From: Charlotte Bodin
Sent: 14 December 2018 13:25
To: 'andy winn'
Subject: RE: Further Information Required on Your Ref: PP-07443527 Our Ref: A/156/18/HH

Thank you for your email. Unfortunately the application is still invalid for the following reasons:

Block Plan shows area bounded by: 506935.9, 104994.14 507025.9, 105084.14 (at a scale of 1:500), OSGridRef: TQ 698 503. The representation of a road, track or path is no evidence of a right of way. The representation of features as lines is no evidence of a property boundary.

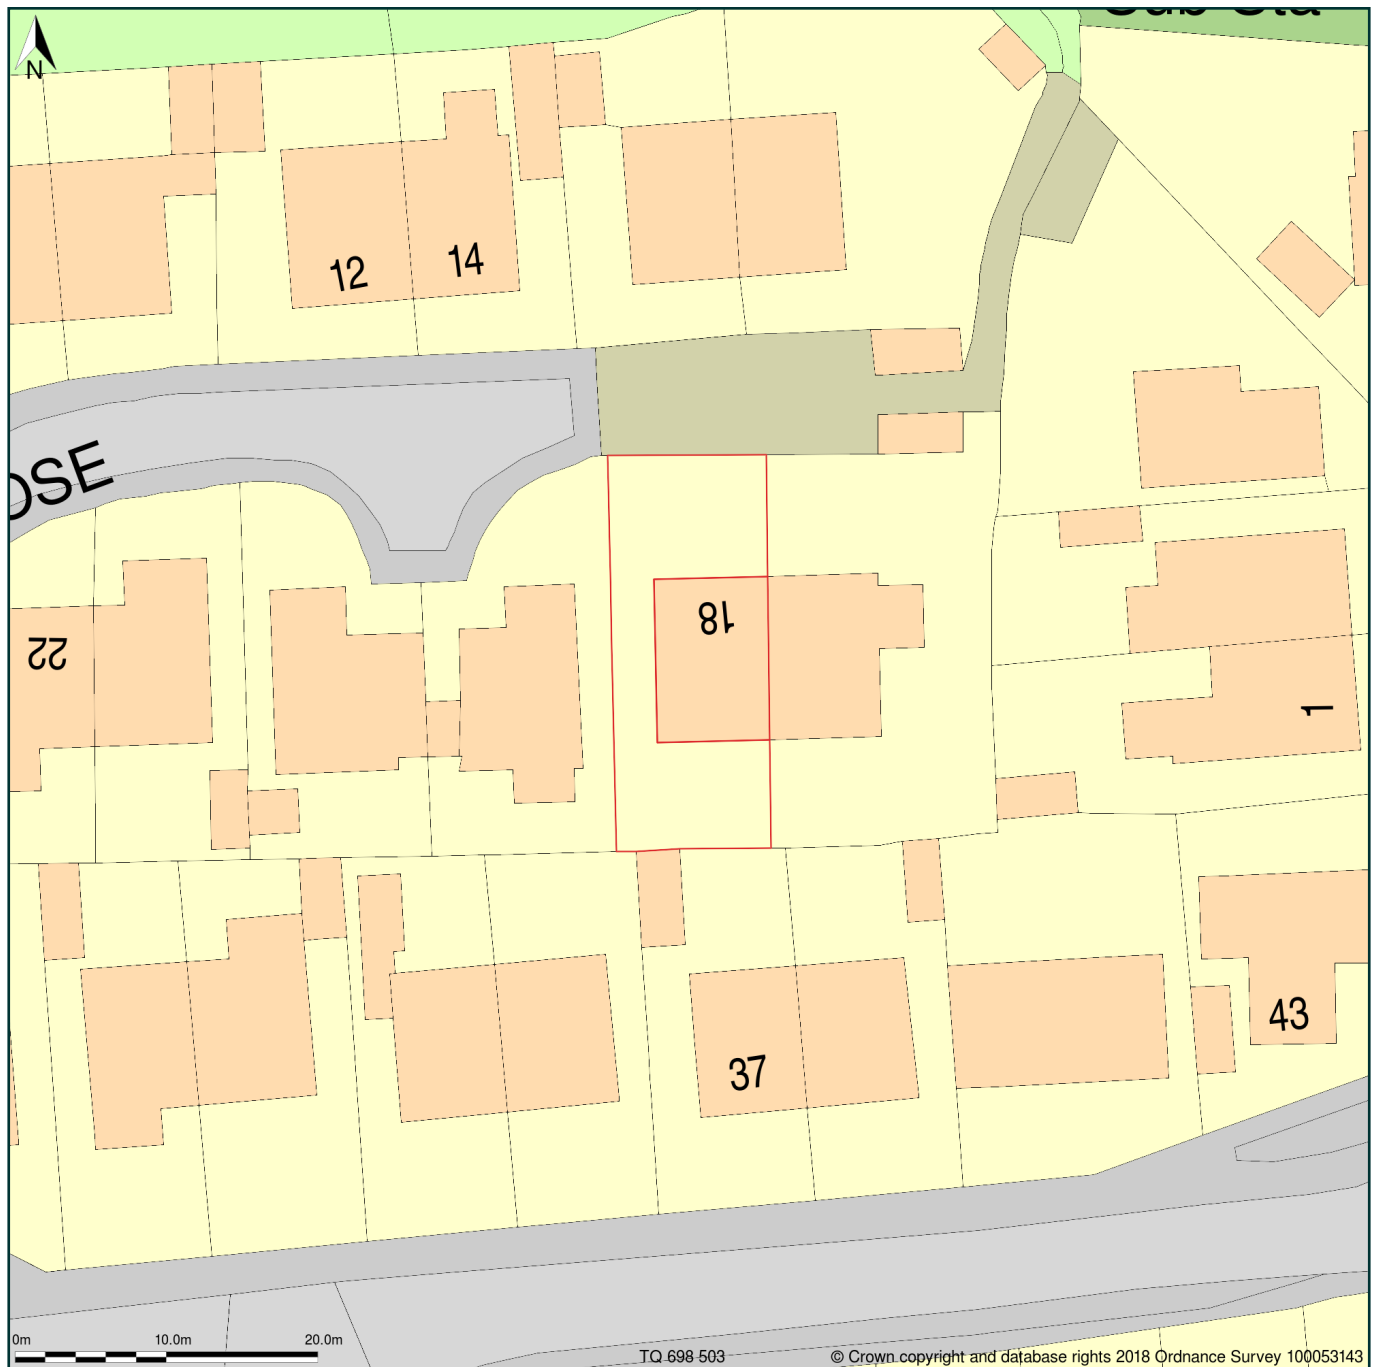
1. Plan Not To Scale: The Block Plan does not show a stated scale. In addition to this the plan has been submitted at a very large paper size so is unlikely to measure correctly to scale;
2. Elevations Required: We require As Built elevations (as the proposal has already been completed), drawn to a stated standard scale such as 1:50 or 1:100;
3. Block Plan Insufficient: You are required to annotate all dimensions from the proposed decking to the boundary. As you have stated in the forms you are also applying for fencing you need to show this on the Block Plan. Please also annotate a title on the drawing.
